Your Ref: OWPC18650
Our Ref: BR/229/17/PL 11-08-2017
Please ask for:
Mr S Davis

Erection of 3 No. dwellings, 1 No. detached garage, parking & alterations to existing access & driveway (resubmission following BR/200/16/PL).

Land to rear of 41 - 47 Pevensey Road Bognor Regis

Thank you for your internet representation made on 6th June 2018 which has been recorded as '**an objection**' with the comments as follows:

Proposed Plans

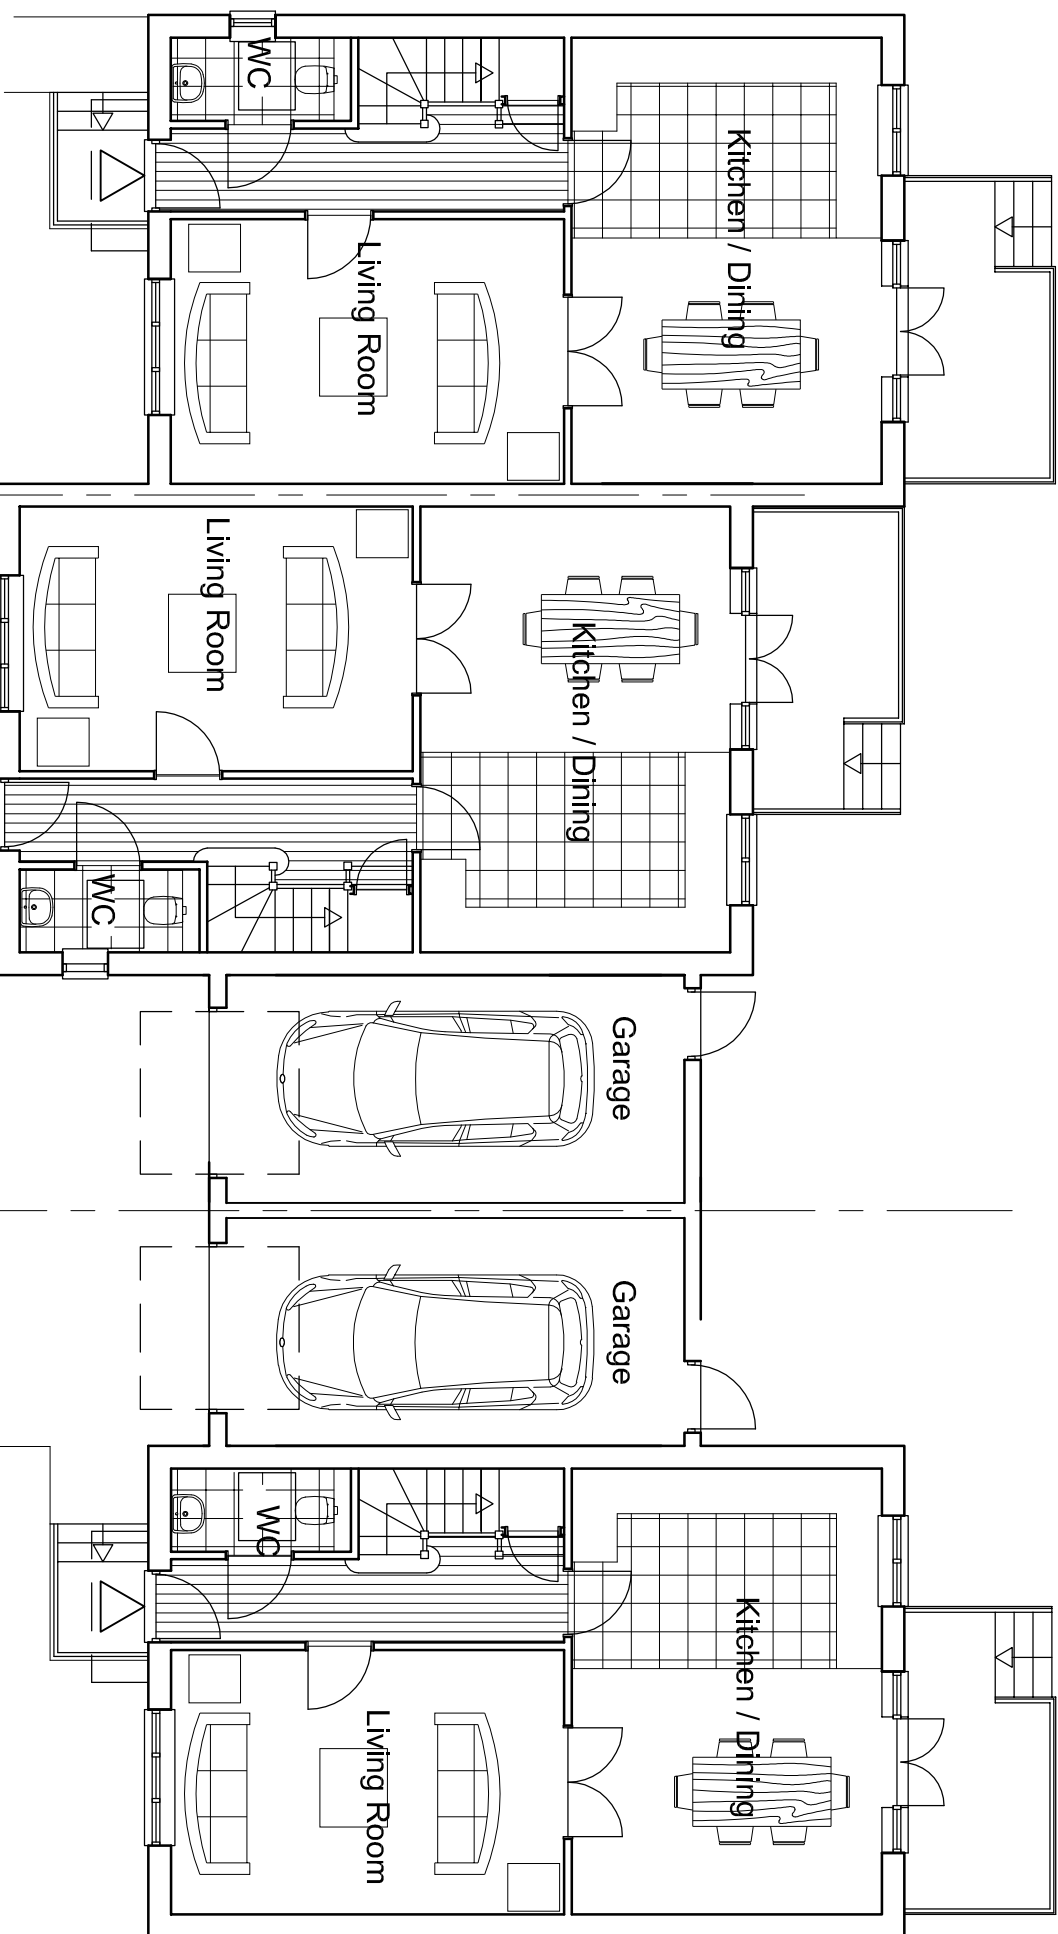
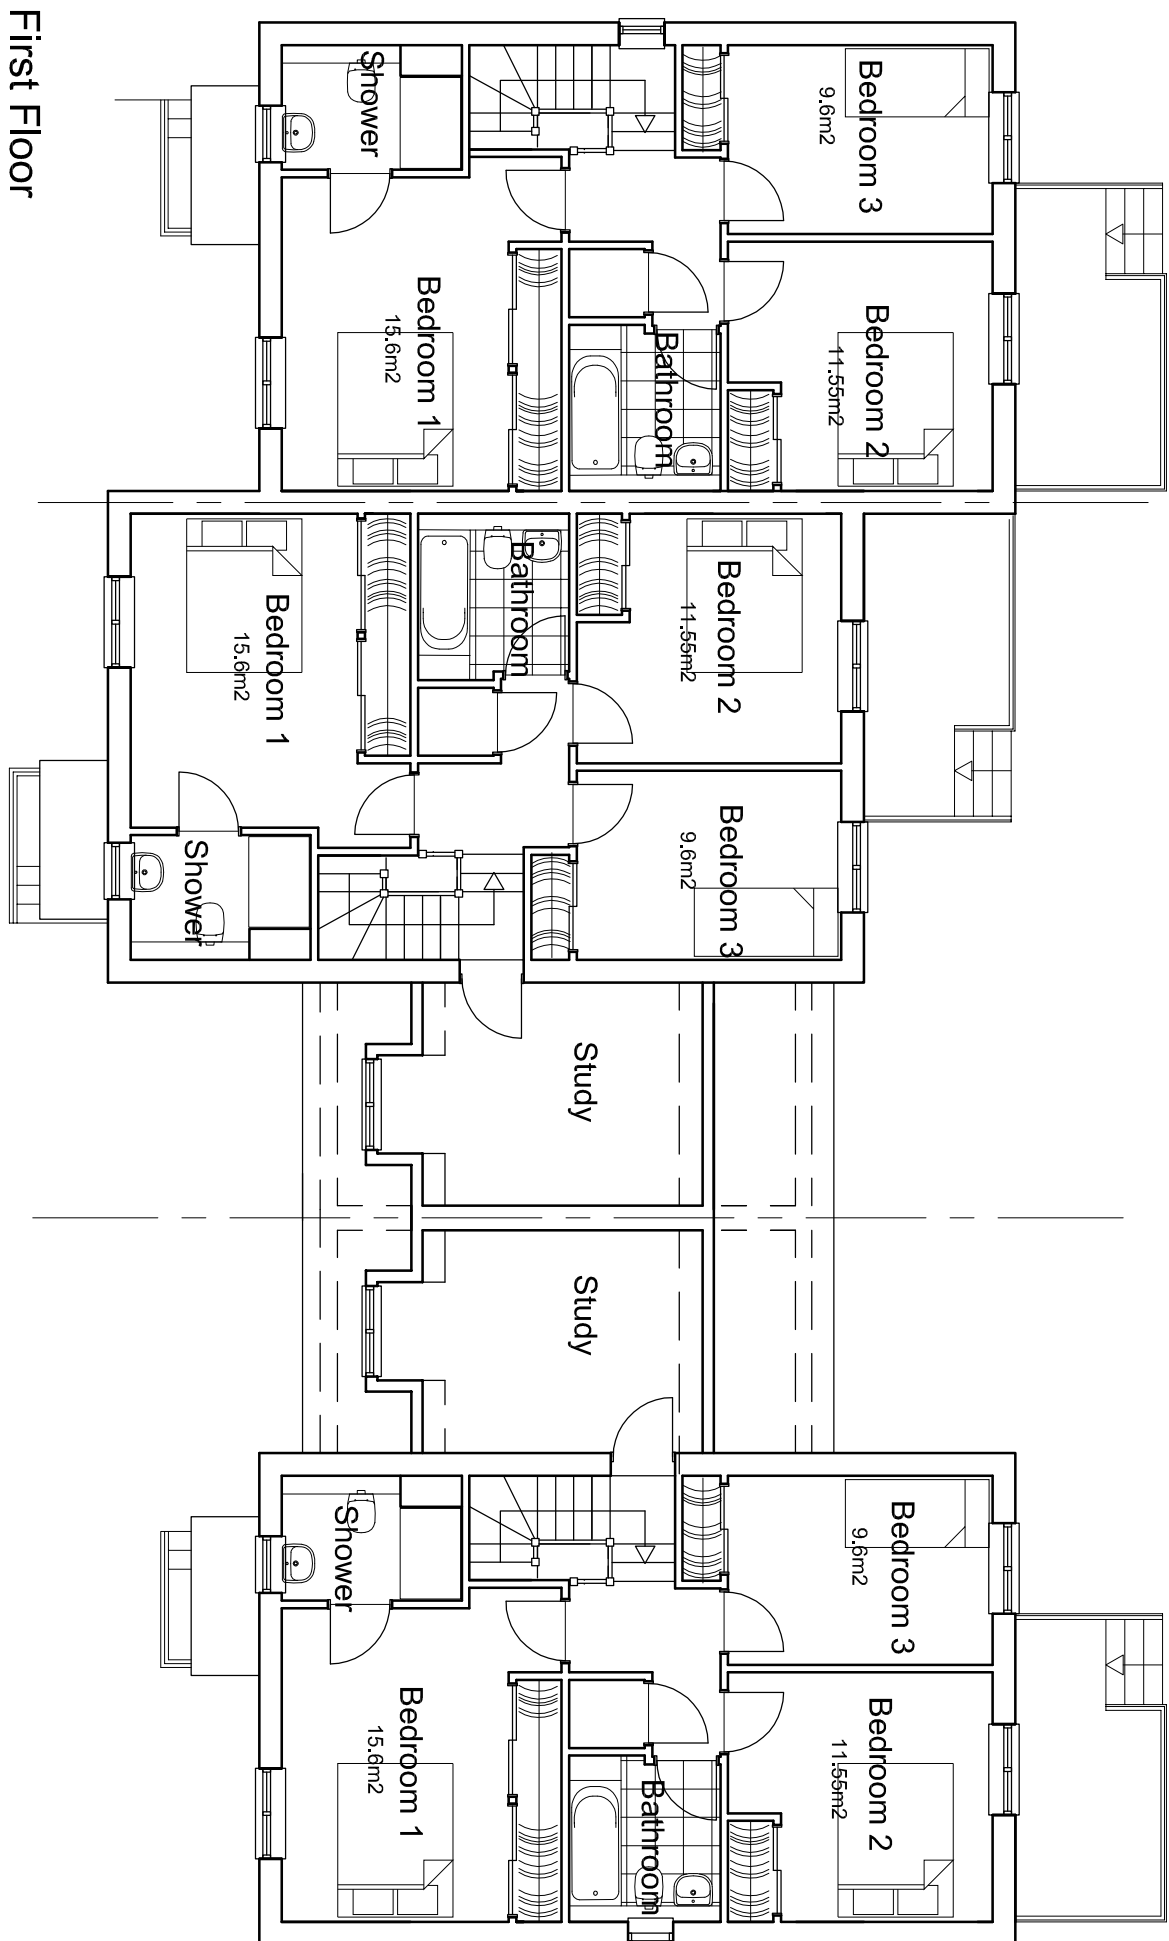
I have looked at the new plans for 3 houses and the applicants may have reduced the dwellings to 3, but have totally missed the point as they have now put a attached double garage with in it's place, it's exactly the same width as the house that was previously there! This has then kept the parking spaces and separate garage in the same area Mr Harverson (Then ADC tree officer) strongly objected to them being in, as they are on top of two protected tree roots.

There are also the large protected trees that are on the border fence of plot 3 these would shade the new smaller gardens of plot 3 so would potentially be removed and could also be damaged as tree roots will have car spaces on them and potentially the foundations of the house to as it's only 5 metres away from the trees and the trees are over 16-18 metres tall so I believe the roots would be underneath the house at plot 3.

DRAWING TITLE	
Block & Location Plans and Site Section	
DATE	SCALE
Feb 18	1:200 @ A1
JOB NO.	DRAWING NO.
1615	2.13
	CHECKED BY
	REVISION
	DRAWN BY
	GIM

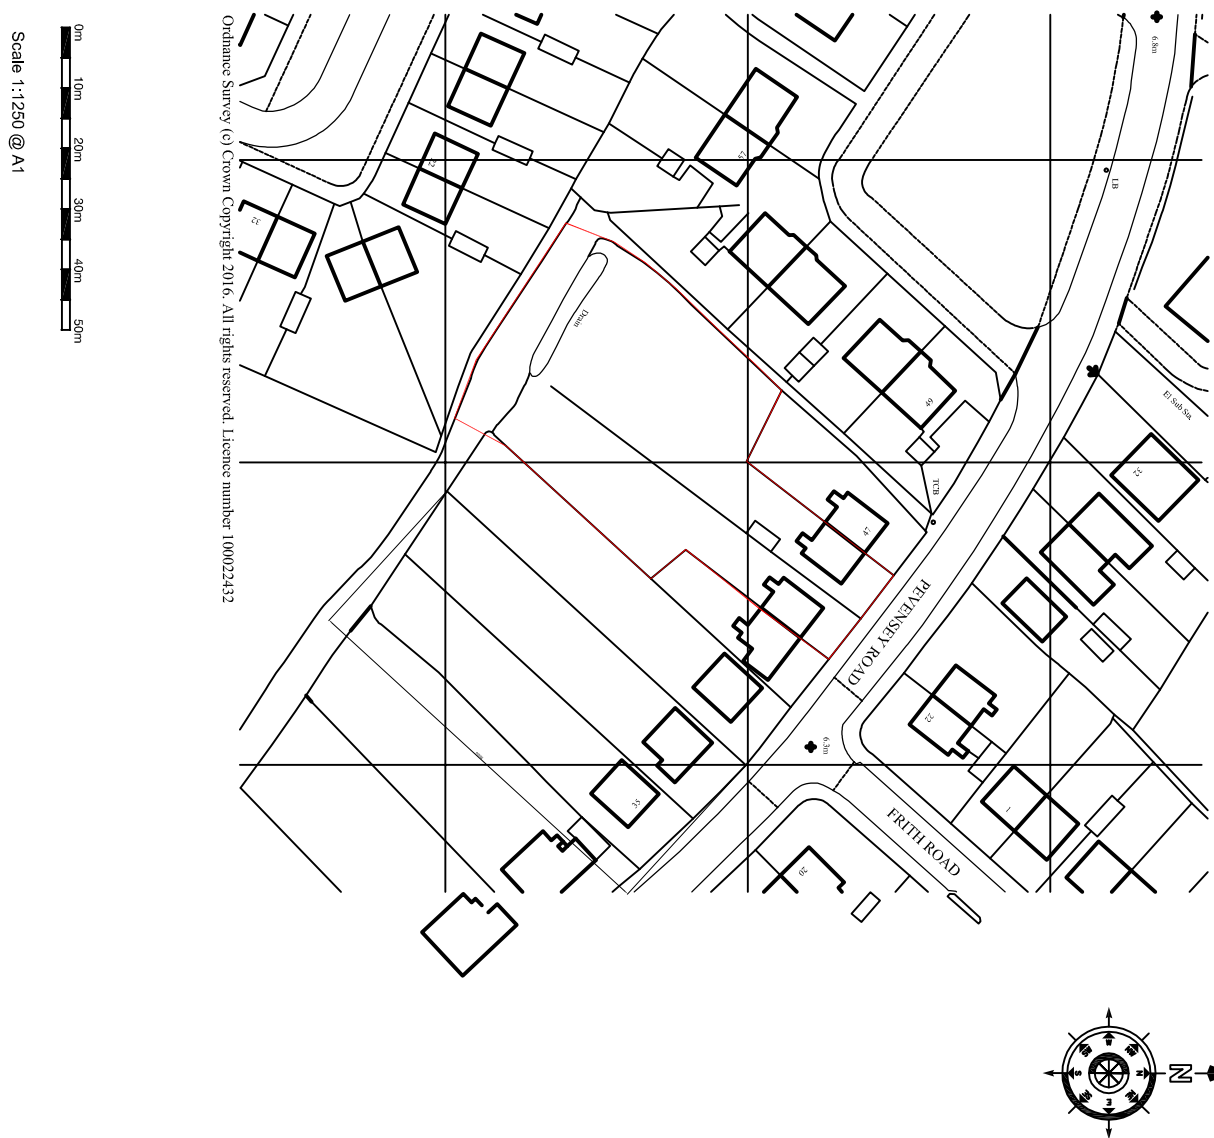
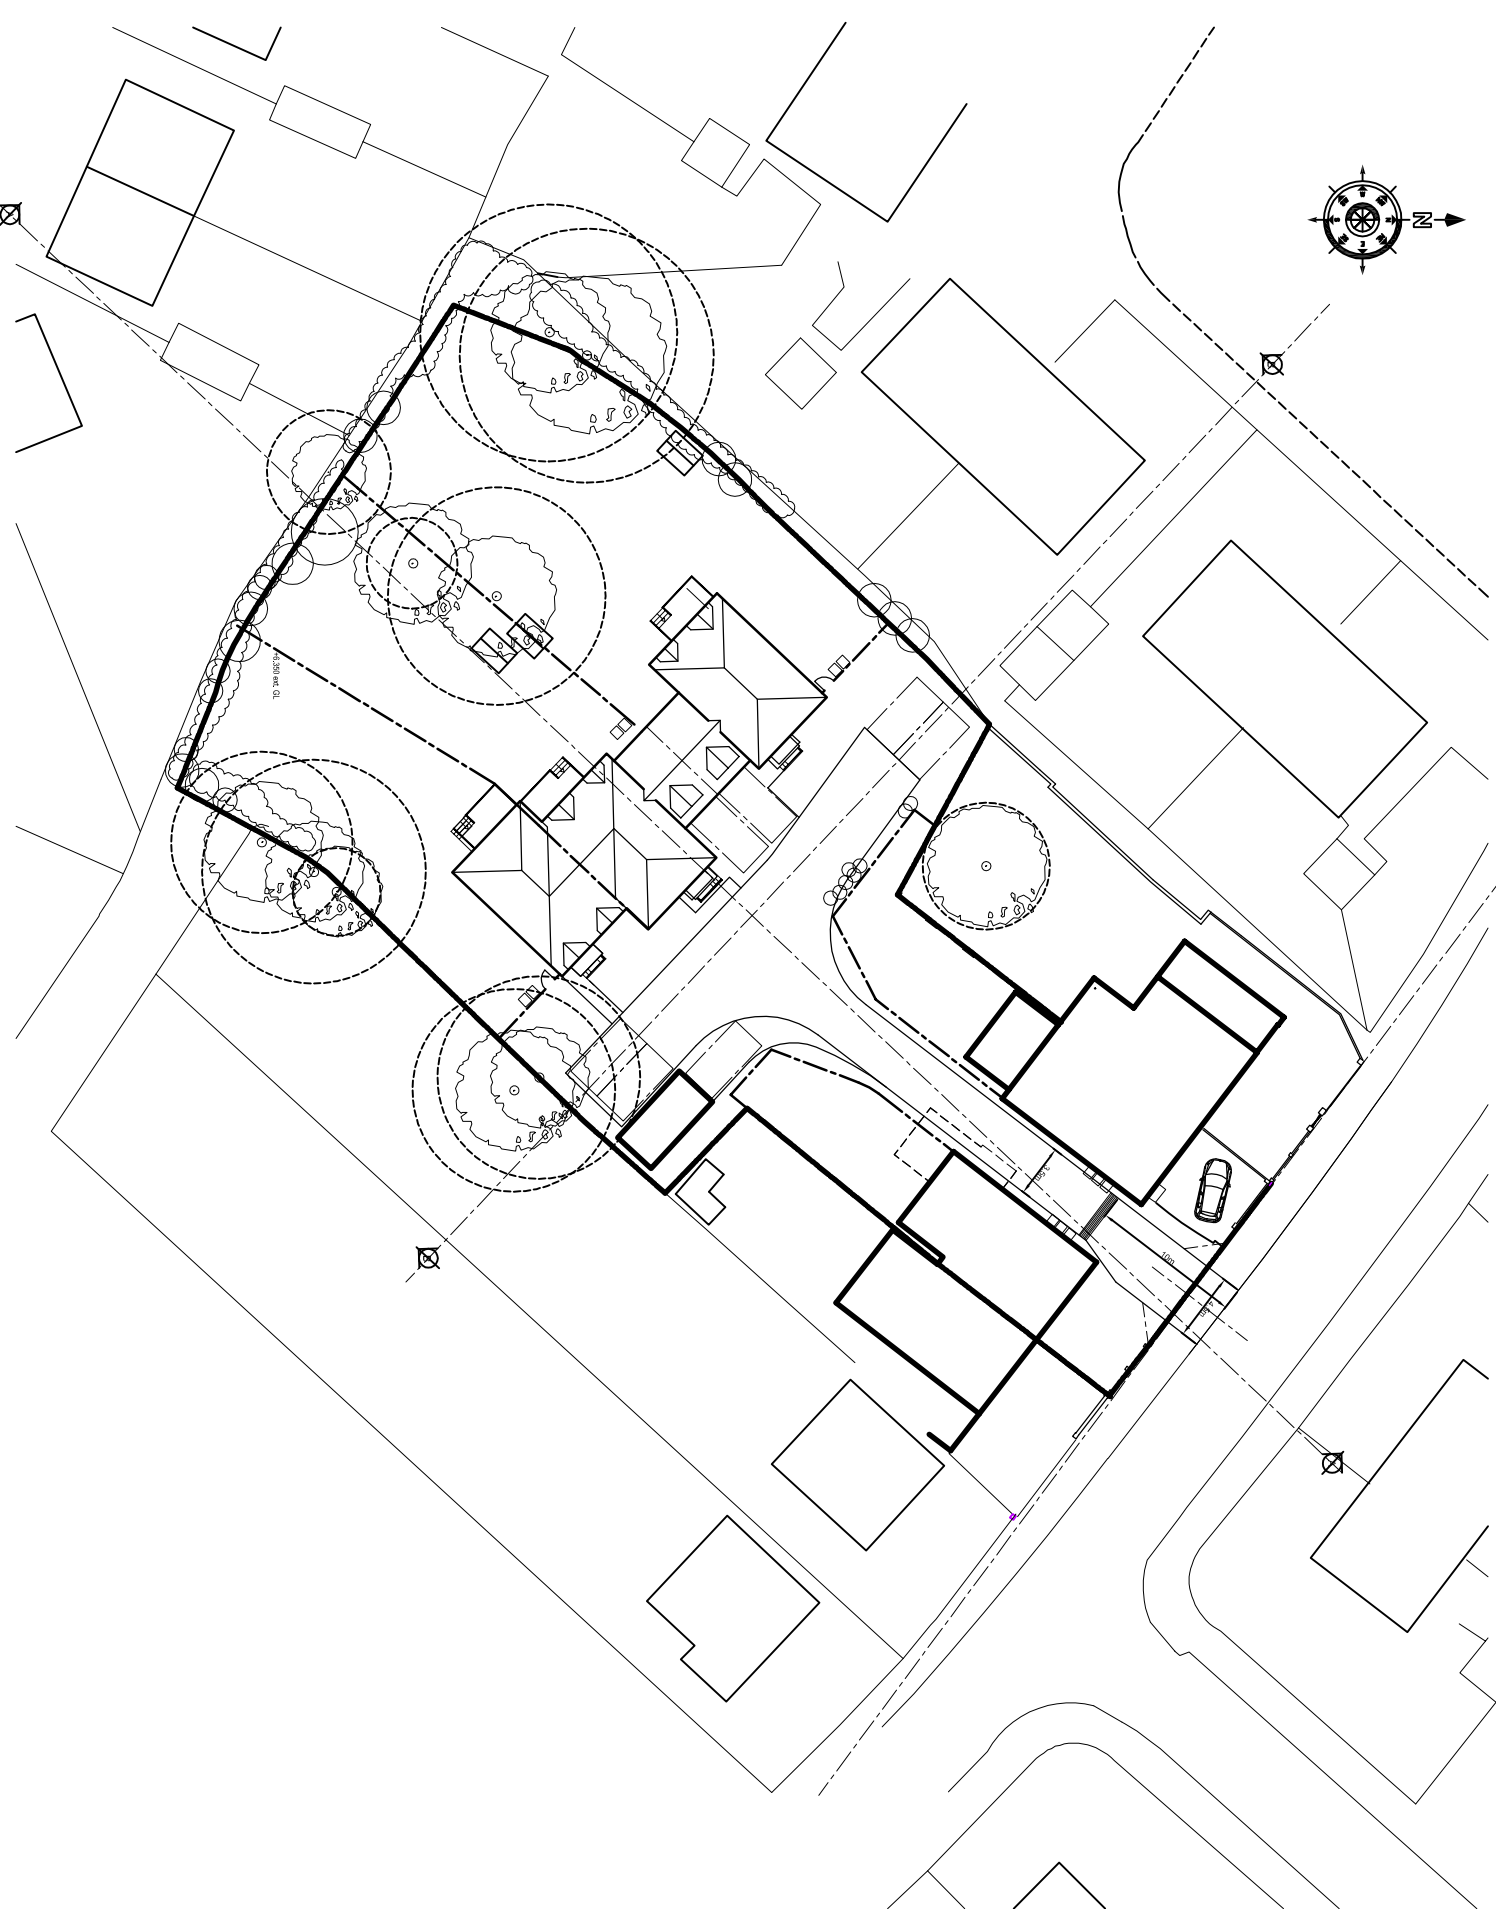
How have the land levels been done properly when half the garden in 45 hasn't been cultivated? It's so overgrown at the back with brambles and nettles it would of been impossible to get any measurements, we believe it has been left like this on purpose to hide the extent of the differences in levels between the two gardens, as 45 has a huge dipped area and is a few feet lower in difference to number 43 as it was previously a copse. And number 43 is the opposite it is high at the end of the garden and then dips down towards the house. So how they think they can put a row of terraced houses on this land without changing all the land levels is a absolute joke. The new gardens wouldn't be level with each other at all.

Both Mr Caan ADC drainage engineer and Mr Harverson have both said in their objections not to change land levels due to damaging protected tree roots and pushing surface water flooding on to others.

Why hasn't the piped drain that runs all along the southern boundary or the land drain in 45's end of garden been mentioned on the plans?
